14th September 2026.

Botley West Solar Farm: EN010147

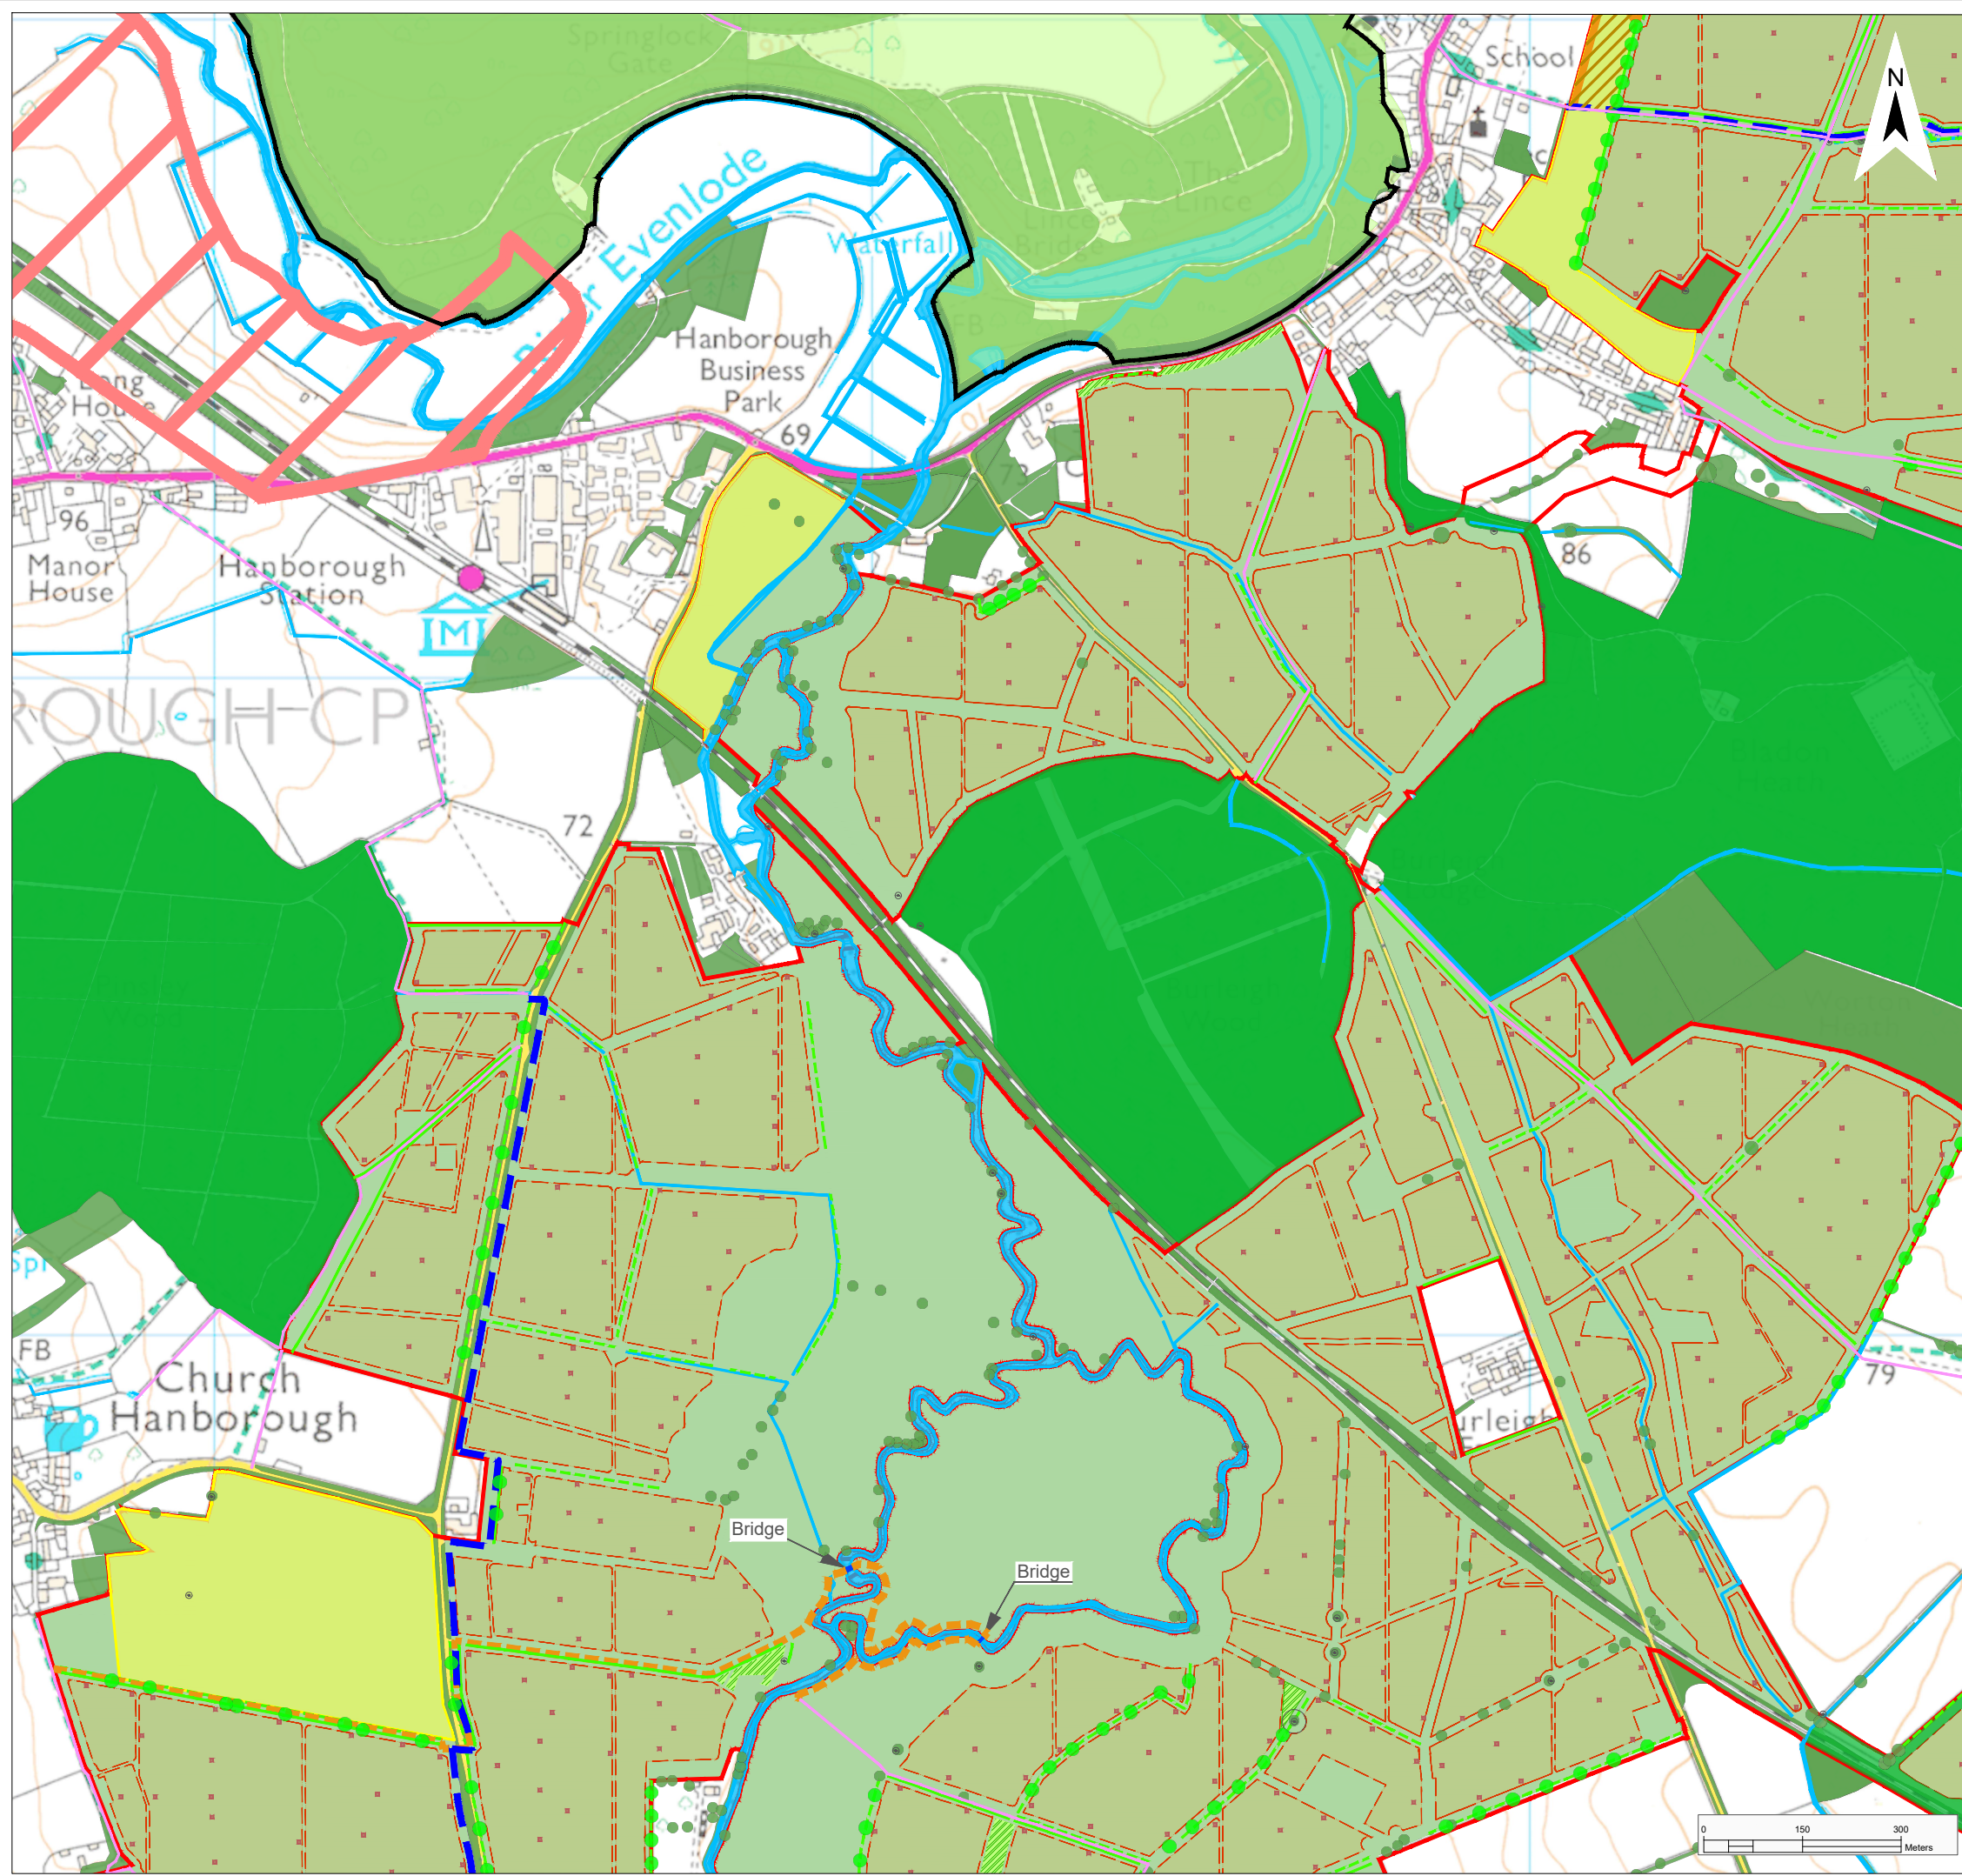
9. **Community food growing** - no further mention. These areas should be removed from the red-line boundary. See REP5-072, REP5-093 and REP6-076
10. **Trainee pilot safety** is at risk with the current panel layout. Further panel removal near the airport is essential. See C2-210 and C2-176

Figure 5 - Illustrative Masterplan

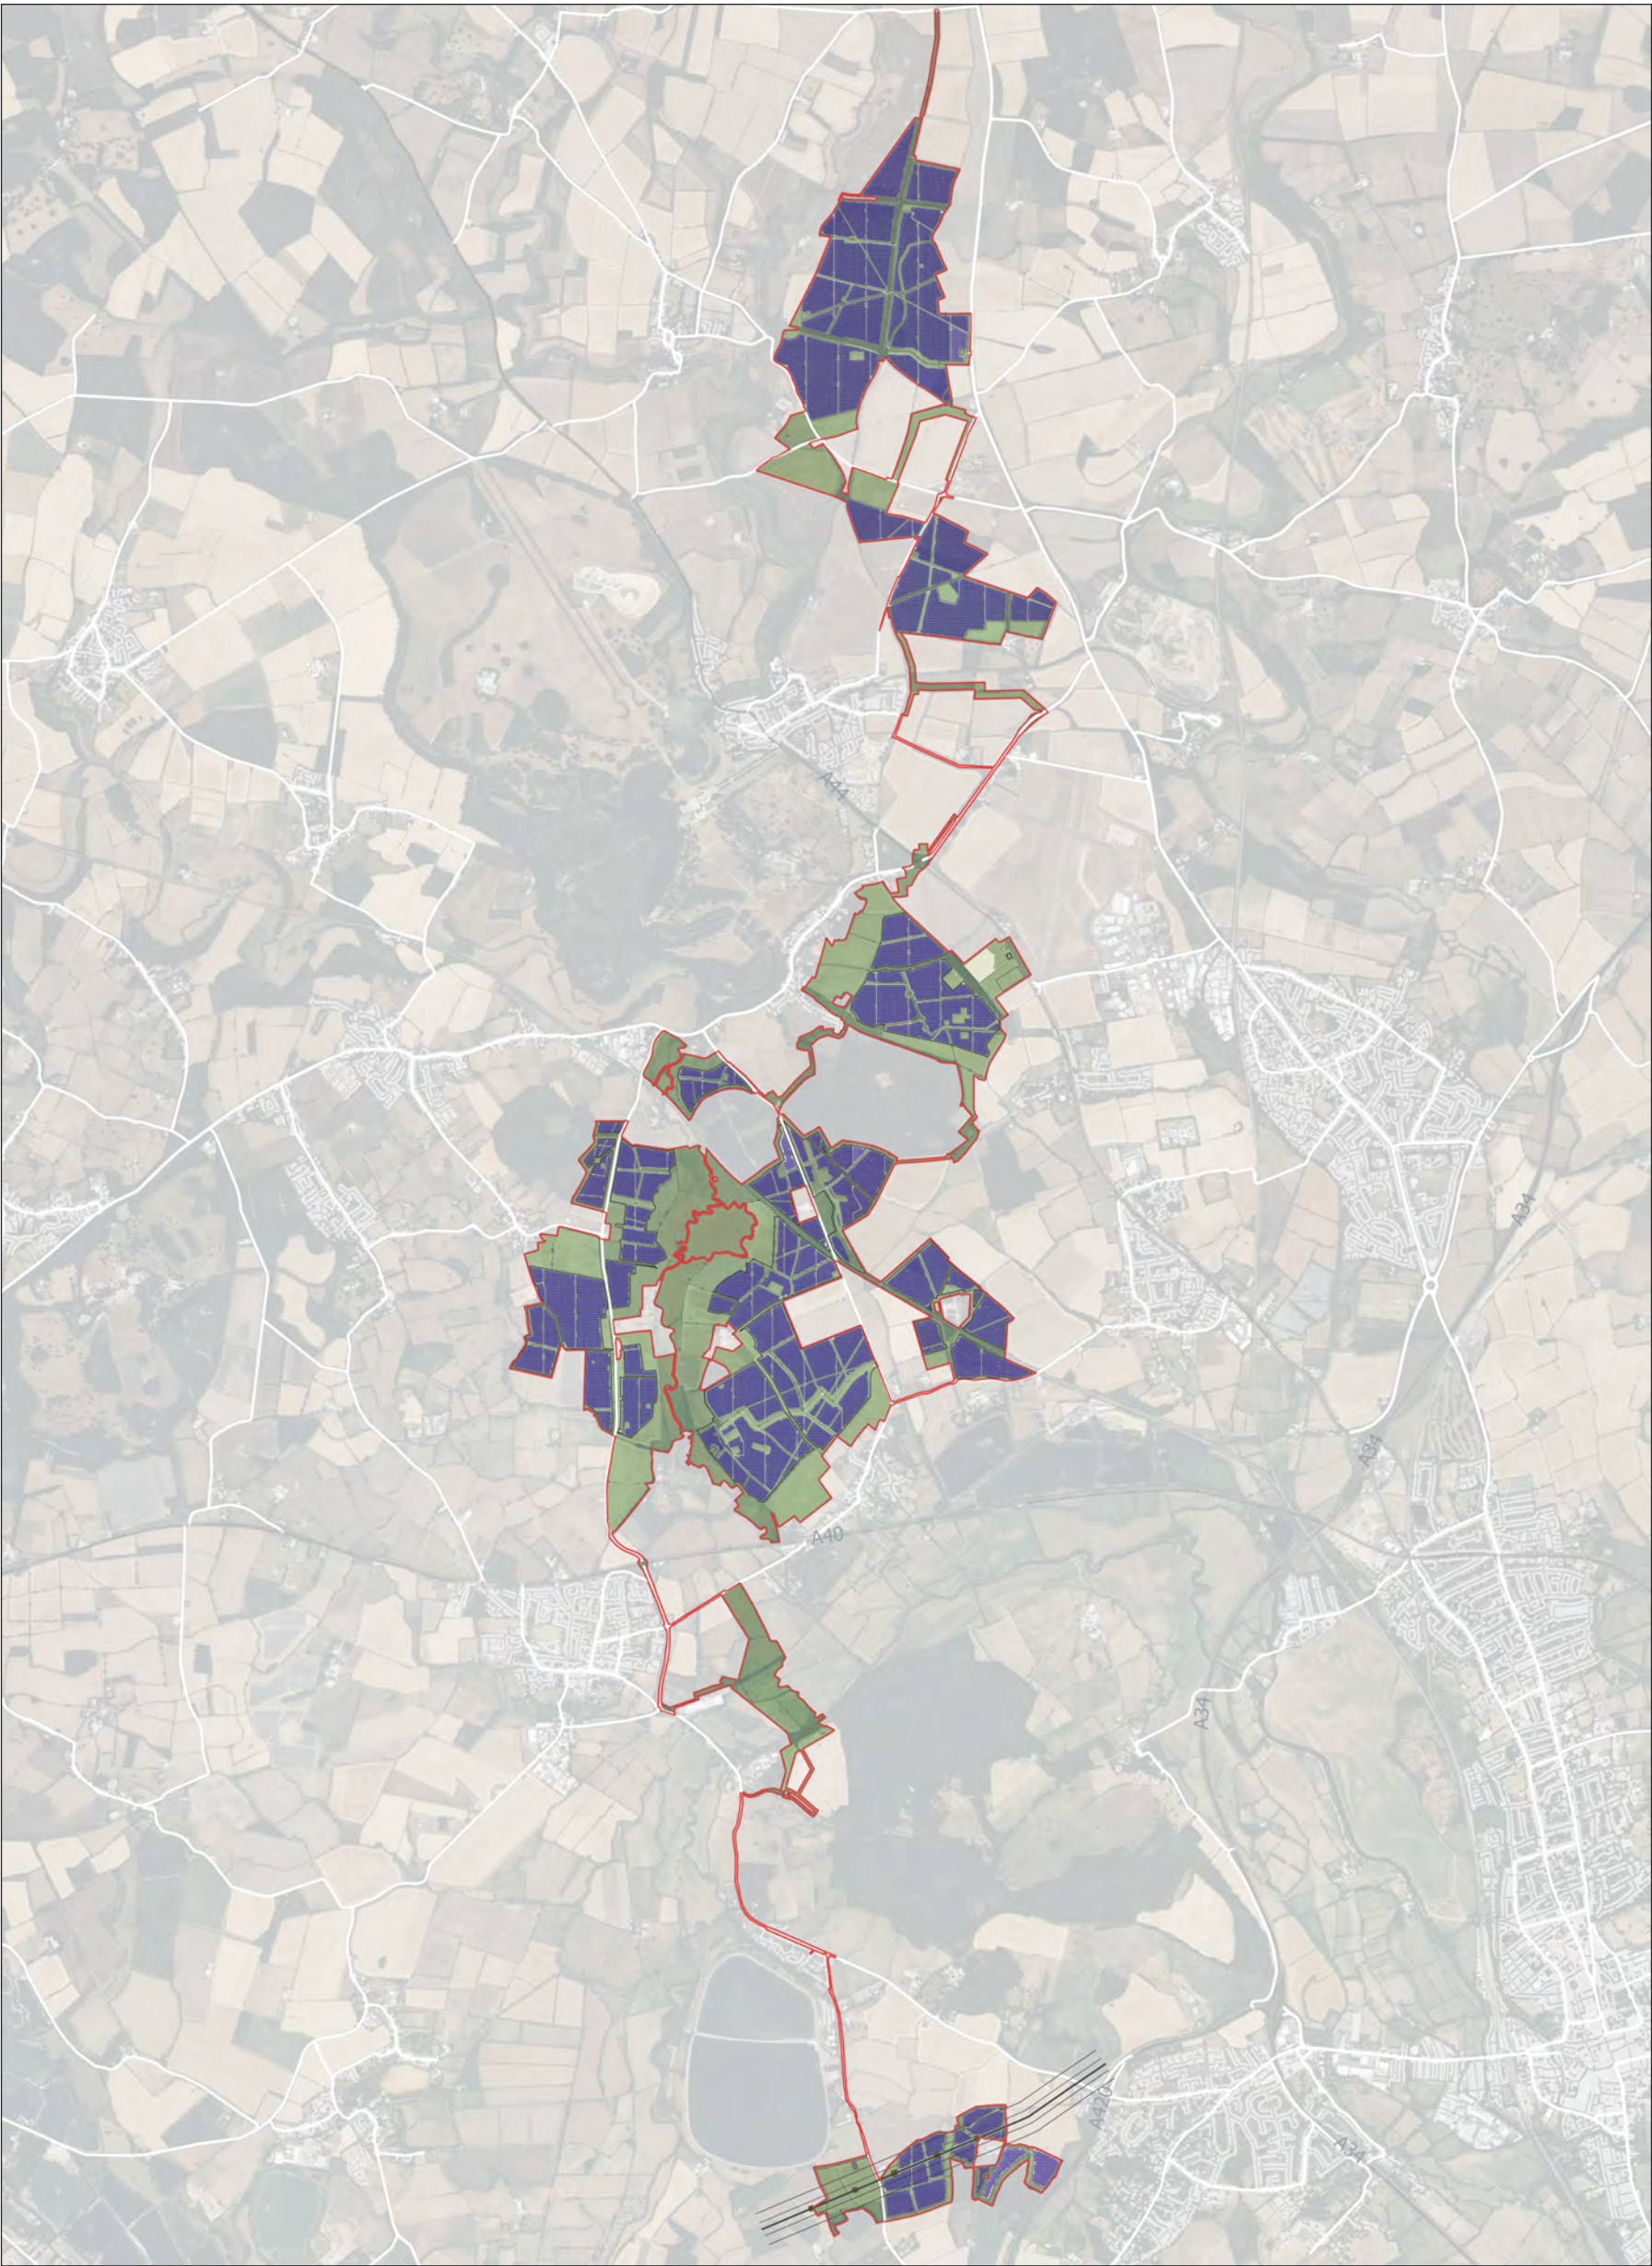
- The principal concern is the introduction of an "outline Residential Visual Amenity Plan" (oRAP) [[C1-108](#)] and new Masterplan revision 5 [[C1-111](#)] in which the default buffer now offered and drawn is 100m (compared with the 250m default recommended by Examiners and previously shown in the Applicant's 9 June masterplan revision 4 [[C1-051](#)] "with additional offsets up to 250m applied where needed". It's not clear how this "need" would be assessed post consent when it will be beyond public scrutiny.

11. **Proposed cycle path** along Lower Rd still shown on Masterplan despite verbal agreement to remove from the Application (during the Examiners' Site Inspection on 7 October 2025).
